Re: BusConnects Belfield/Blackrock to City Centre Core Bus Corridor Scheme
Co. Dublin

The Woodbine Glenomena Resident's Association (part of the wider 'Montara' forum of resident's associations) wish to make observations on the planning submission for the Belfield / Blackrock to City Centre Bus Corridor Scheme. We think the time allowed to review such a substantial, technically demanding planning submission is difficult especially at this time while schools are closed and many of our residents are on holiday. This comes on the back of an earlier proposal to extend the cycle track from Booterstown Dart station and other changes to reduce the Trimleston Avenue to a single lane at the Rock Road junction. However, we have the following observations to make:

Seafield Resident's Association, part of the wider 'Montara' forum of residents' associations, wishes to make observations on the proposed Belfield /Blackrock to City Centre Core Bus Corridor Scheme.

BusConnects Dublin - Belfield / Blackrock to City Centre

Drawing File Name: BCIDC-ARP-GEO\_GA-1415\_XX\_00-DR-CR-0008 | Sheet Number: 08 of 24 | Status: A | Rev: M01

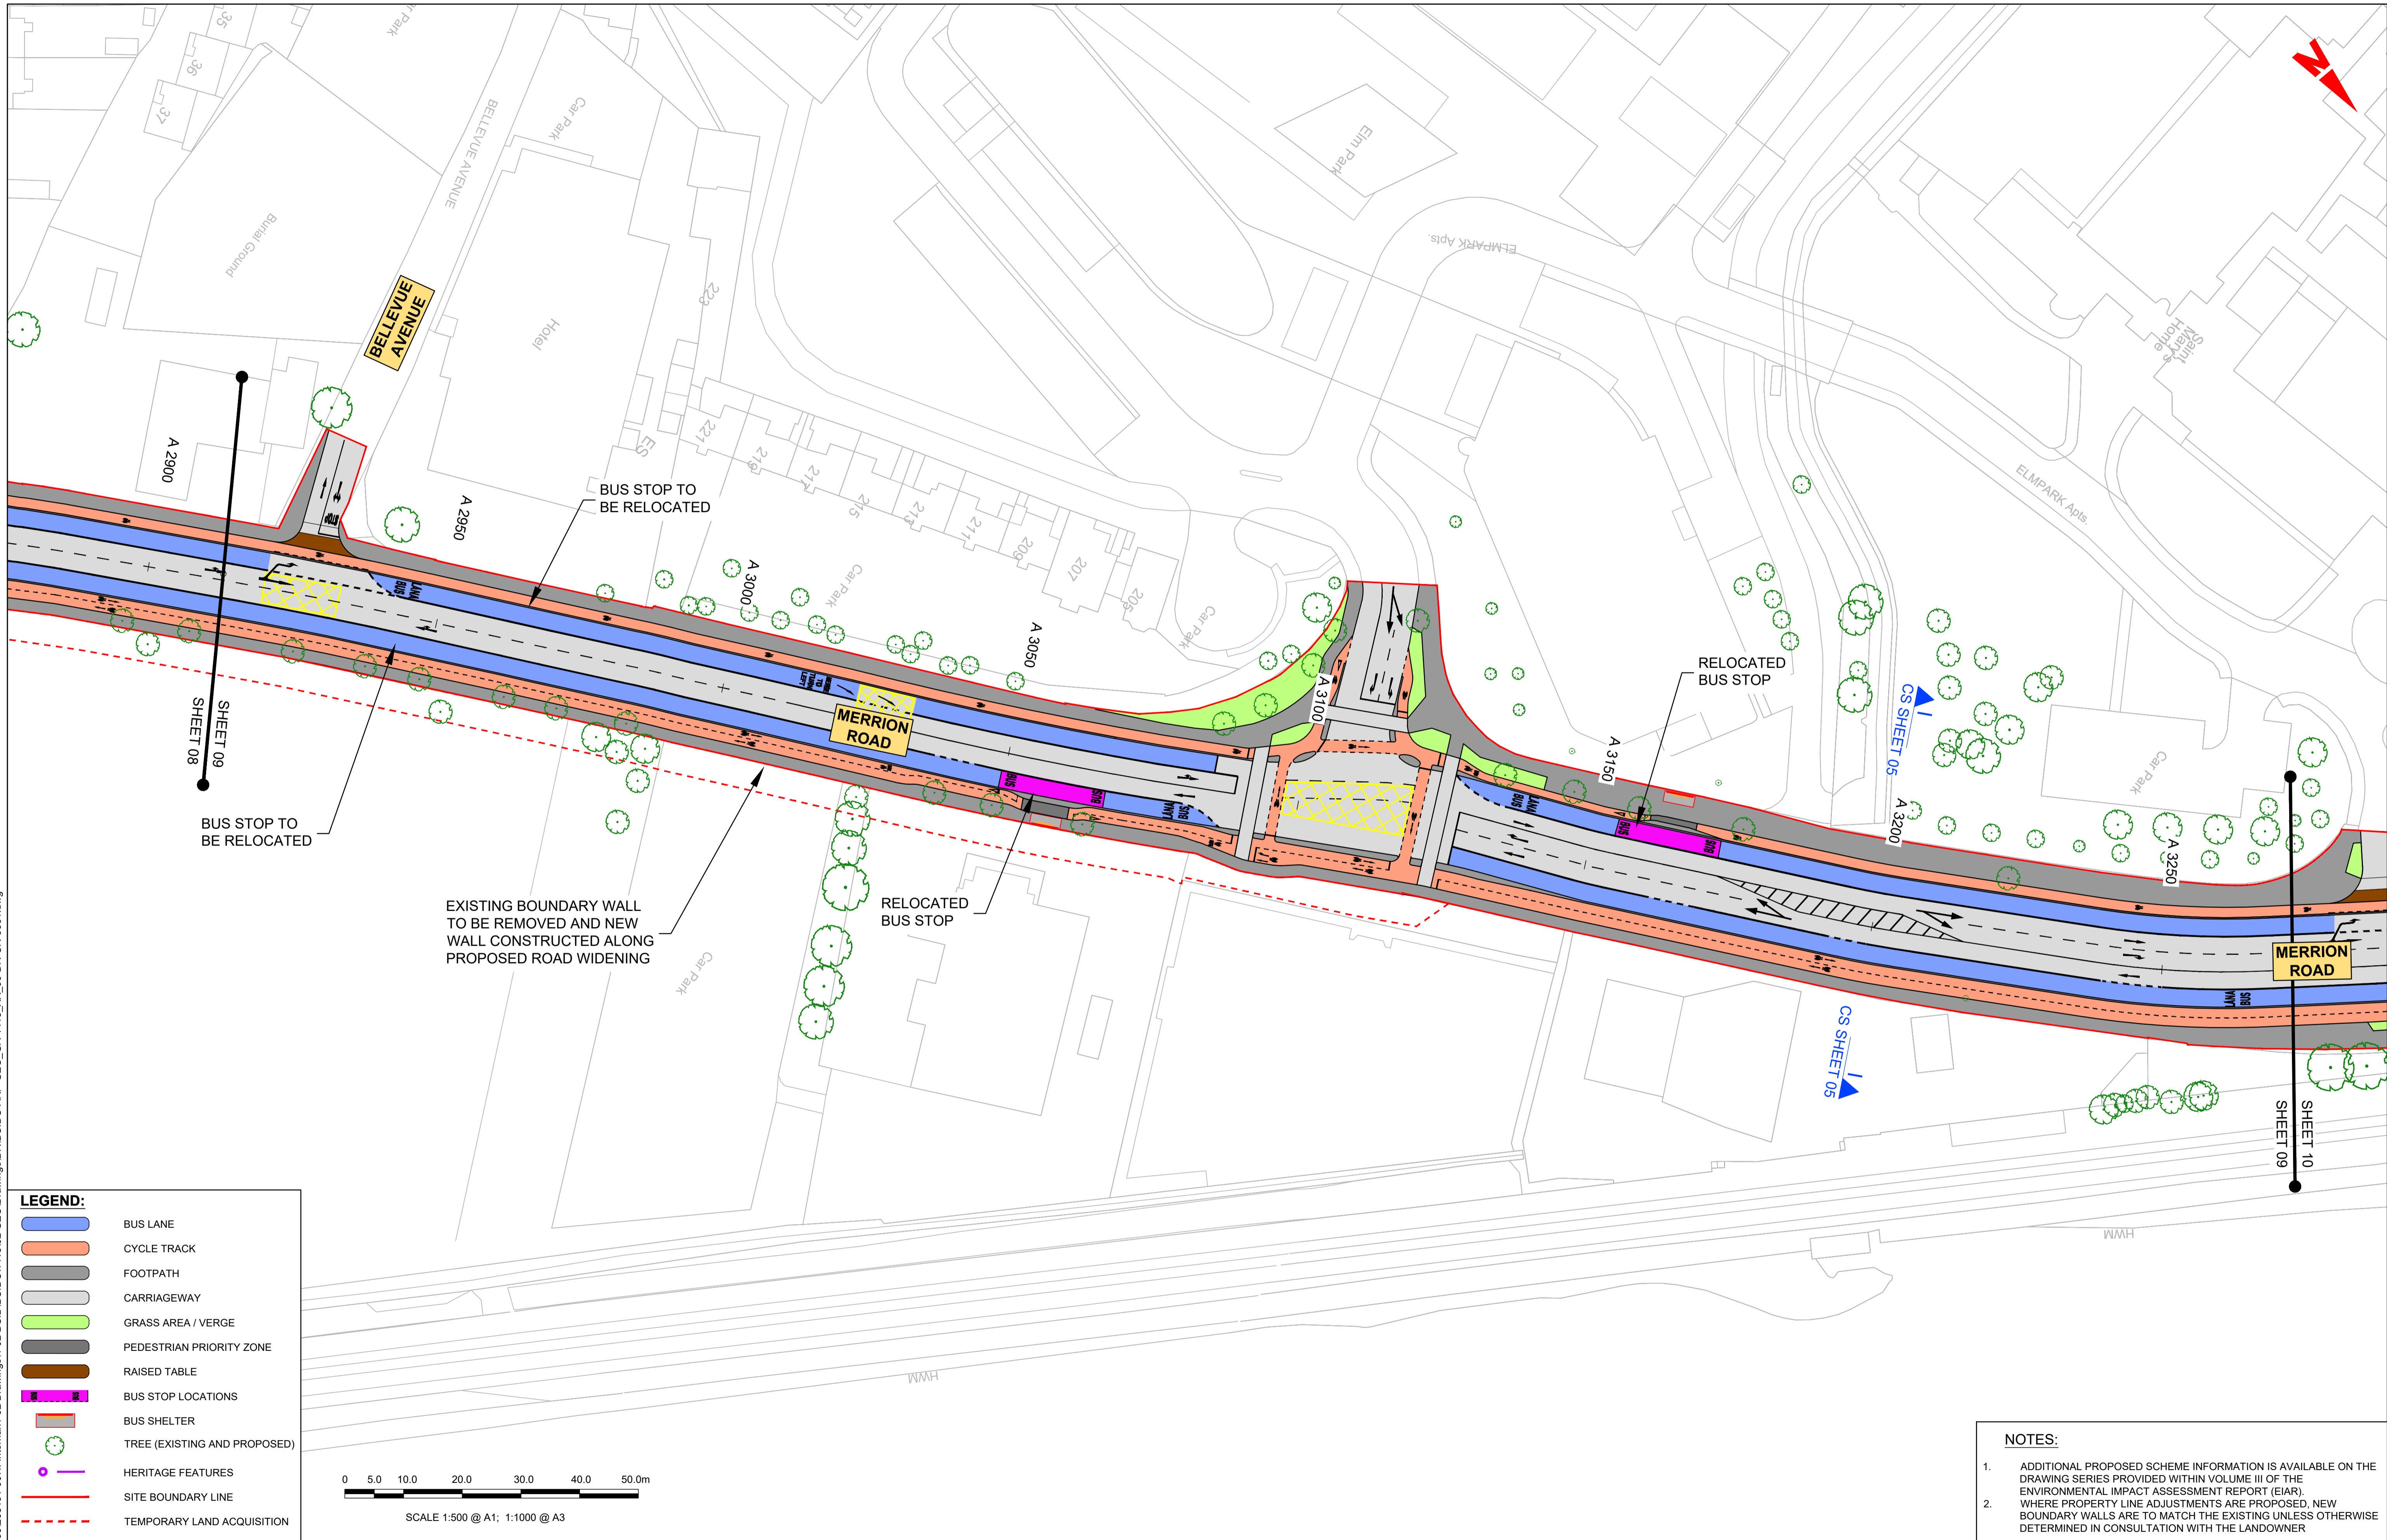
Our proposals are in relation to section sheets 8 and 9 of the general arrangement drawings:

- a) Trimleston Avenue entrance currently has two lanes here where one is a filter to support traffic turning left on to Merrion road.
 - a. Our proposal: is for these two lanes to remain as is.

- b. Resident concerns: Increased traffic congestion across the Trimleston estate including the main road Woodbine to Trimleston. Our estate has a large community and removing this filter will not allow for ease of traffic and will cause an increase in the overall congestion in the estate as well as the surrounding roads. At present, we are already seeing traffic backed up the estate with the existing two lanes so to propose to remove these will only make the matter worse.

- b) Merrion road currently has a right turn (filter/slip lane) to allow for traffic into Trimleston Avenue.
 - a. Our proposal: is for these two lanes to remain as is.

- b. Resident concerns: With the suggested removal of this filter lane this will cause disruption and a standstill of traffic. Residents are concerned about the access into the estate and the increase of traffic congestion in that area with the removal of a filter lane. This will also lead to potential accidents where there will be a requirement for a cyclist or motorist to take this right turn all in the same lane as the ongoing traffic. We suggest that the filter lane remains.

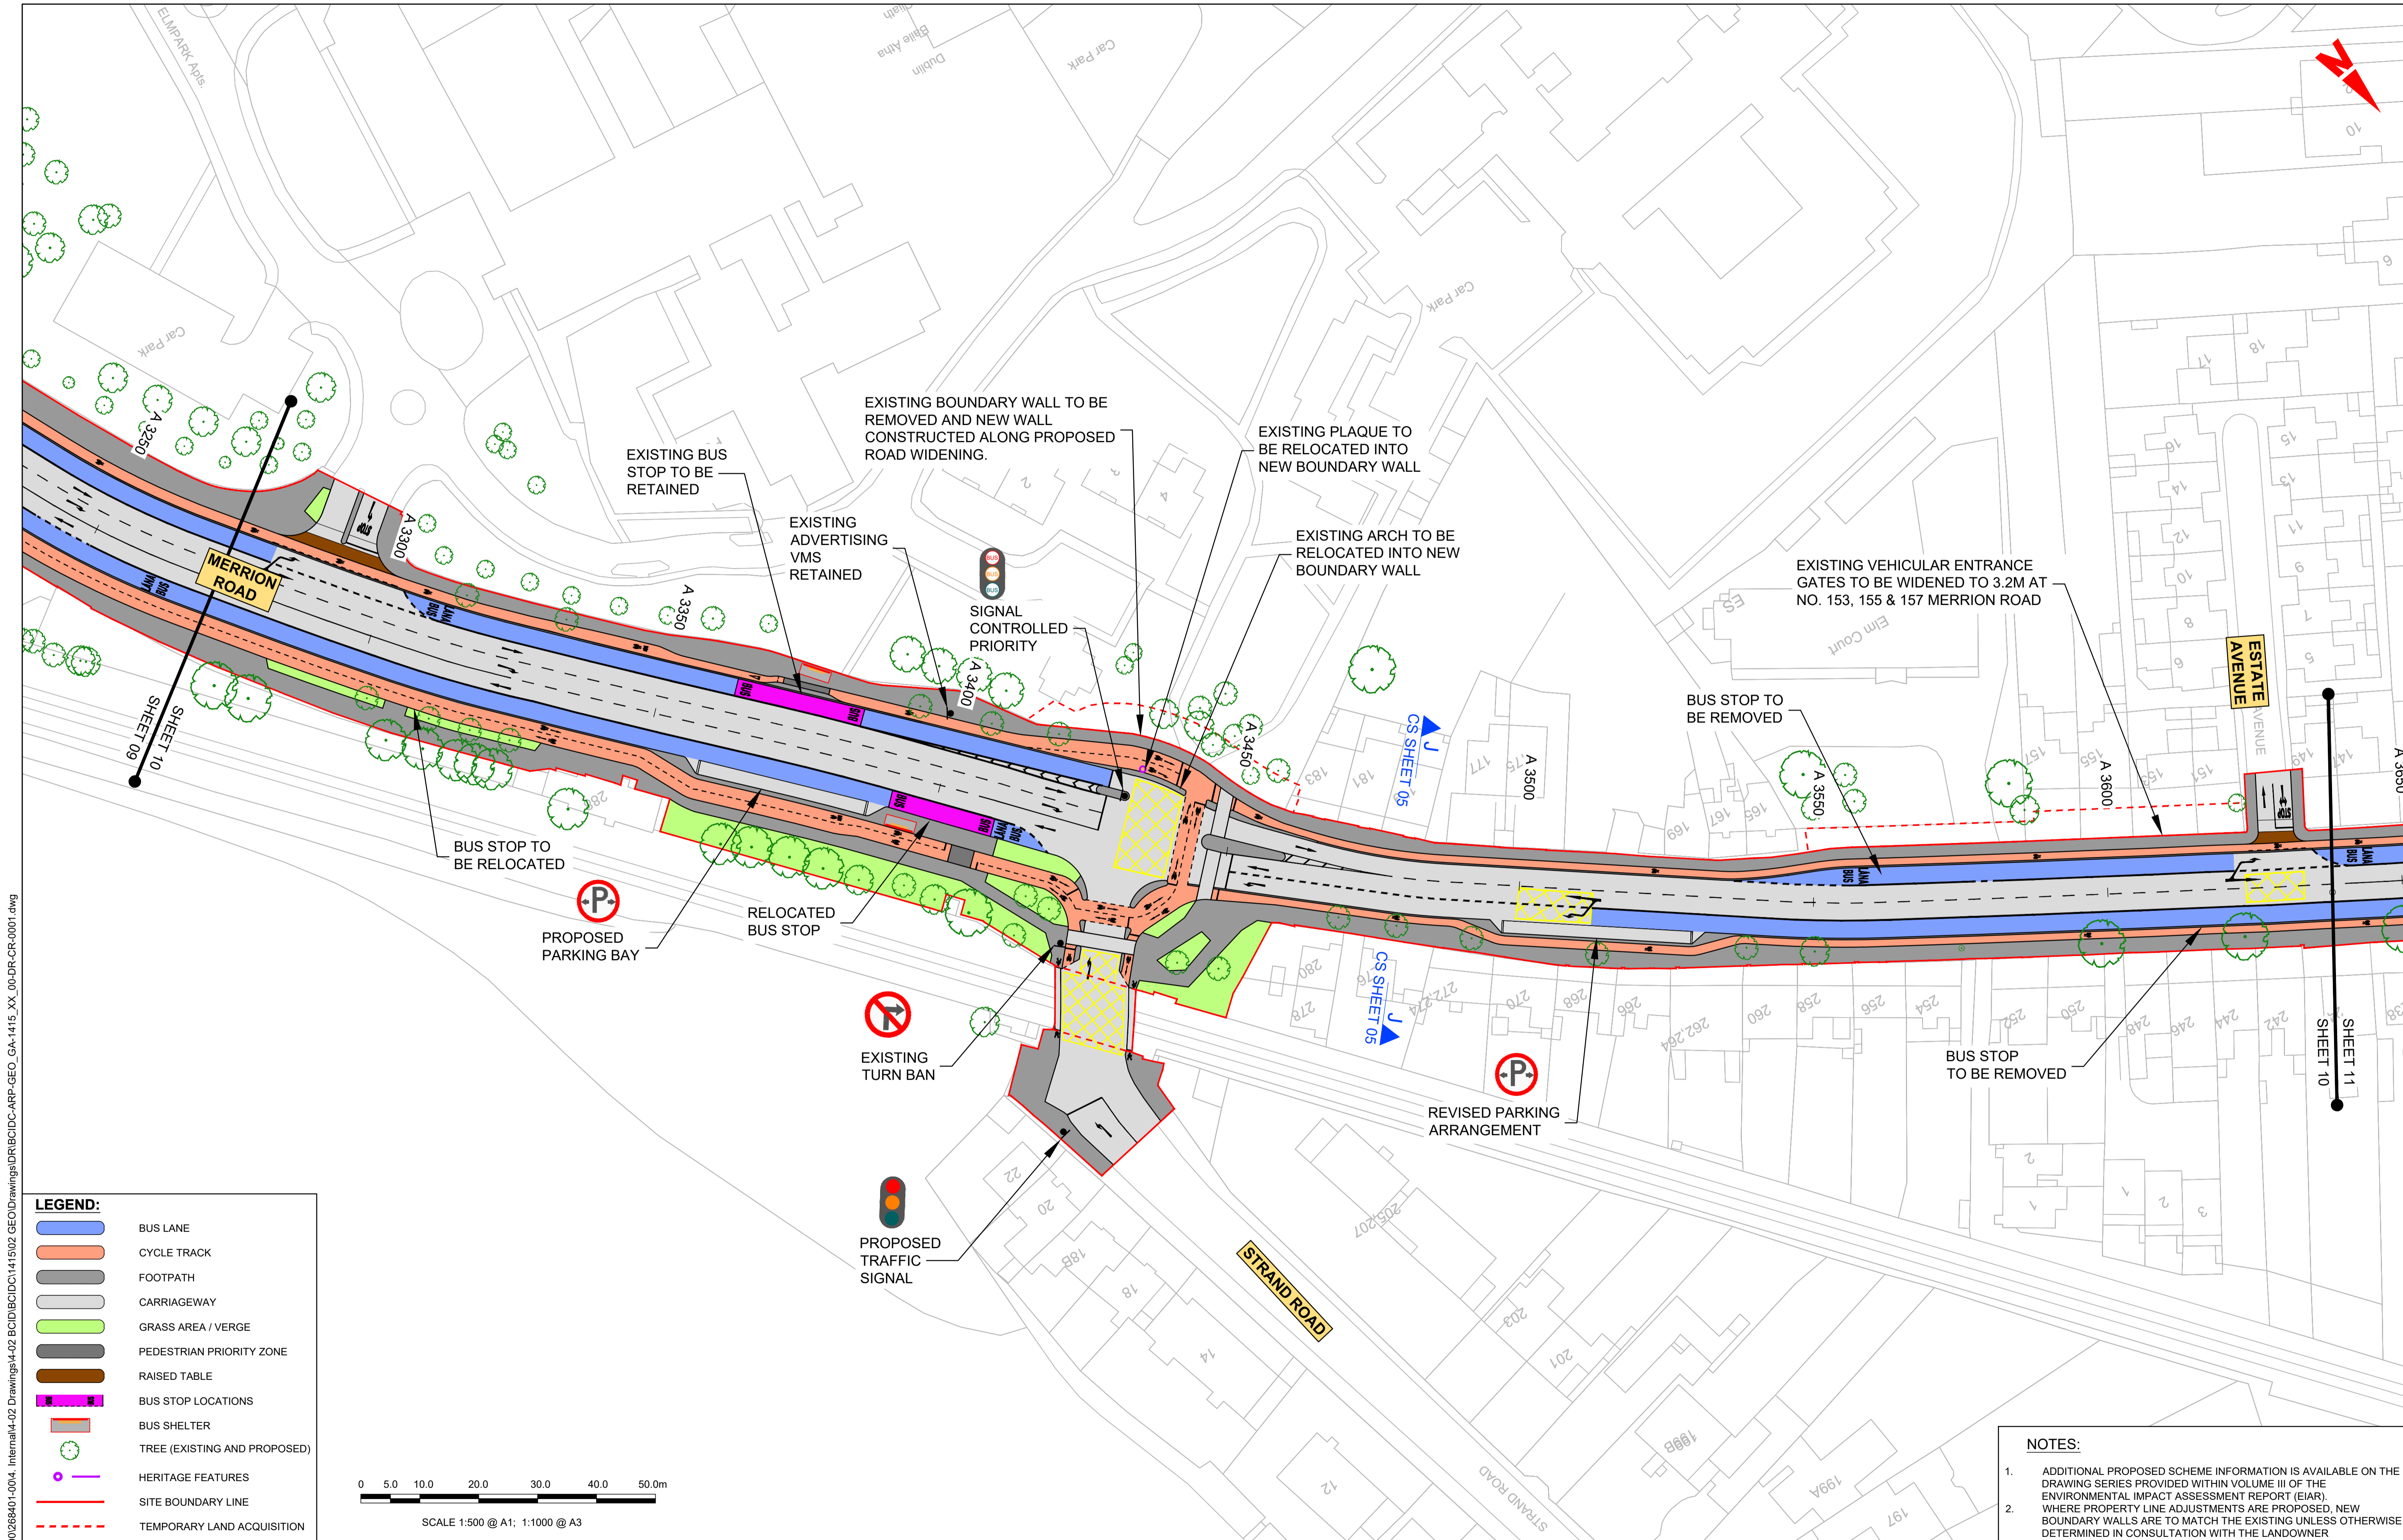
c) In sheet 9 and 10, we are concerned regarding the suggested removal of TWO HISTORIC arches on the Merrion Road. It is not clearly mentioned in your Environmental Impact Assessment Report that both these arches are in fact historic and protected structures.

We are concerned that the plans are suggested to potentially move these arches further down the street. From our review the Historic Entrance Arches are protected.

a. Our proposal: is for these arches to remain as stands in their rightful place along with the Merrion Castle, which date of construction is going back to the 15th century.

b. Resident concerns: We are concerned that such protected Architectural and historical, structures are being moved and potentially could be damaged in the process of the proposal.
